**RE: Wagga Wagga Rural Referral Hospital Redevelopment Stage 3 (SSD 9033)**

Thank you for your letter dated 16 July 2018 requesting Transport for NSW (TfNSW) provide comment on the above State Significant Development (SSD 9033).

The proposed Stage 3 of the redevelopment includes the construction of a seven storey ambulance care building and car parking for an additional 107 vehicles.

**Figure 7.2: Edward Street/ Docker Street intersection upgrades (highlighted in blue) due to background traffic growth**

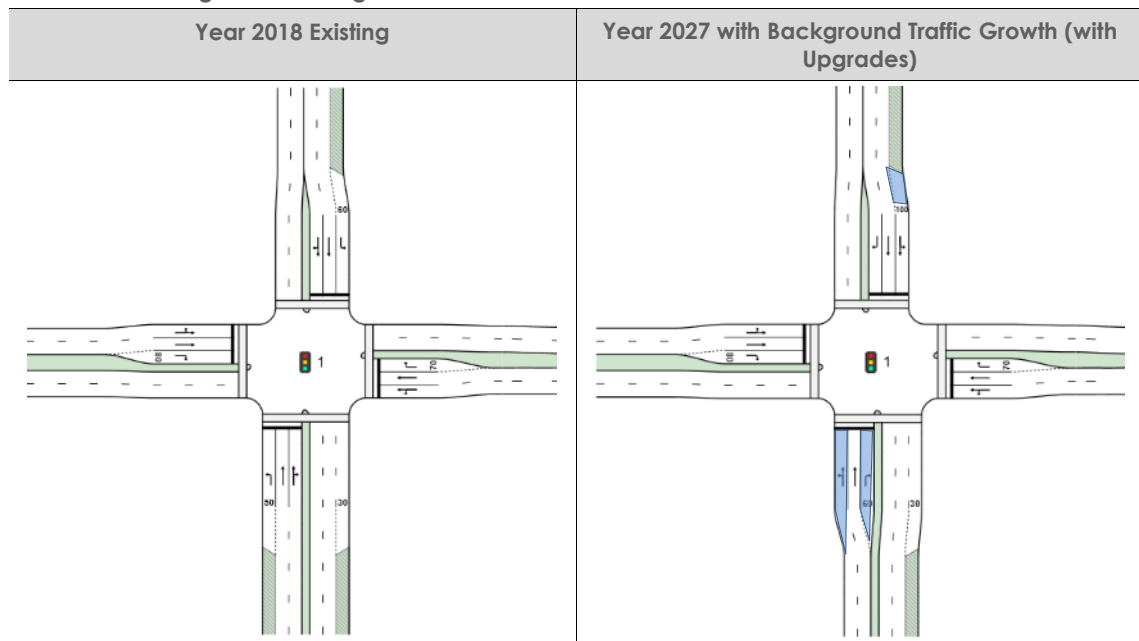
- Further consultation with Roads and Maritime Service is required to determine the appropriate mitigation and funding measures for Edward Street / Docker Street and Edward / Murray Street intersections
- There are 2 bus stops in the vicinity of the hospital. Access to these bus stops may be impacted by improvements to the Edward Street / Docker Street intersection, both during operation and the construction period.
- Access to the bus stops should be maintained at all times during construction, which should be specifically addressed as part of the Construction Pedestrian Traffic Management Plan.
- Further consultation with the local bus operators and TfNSW regarding the aforementioned intersection improvements is recommended.
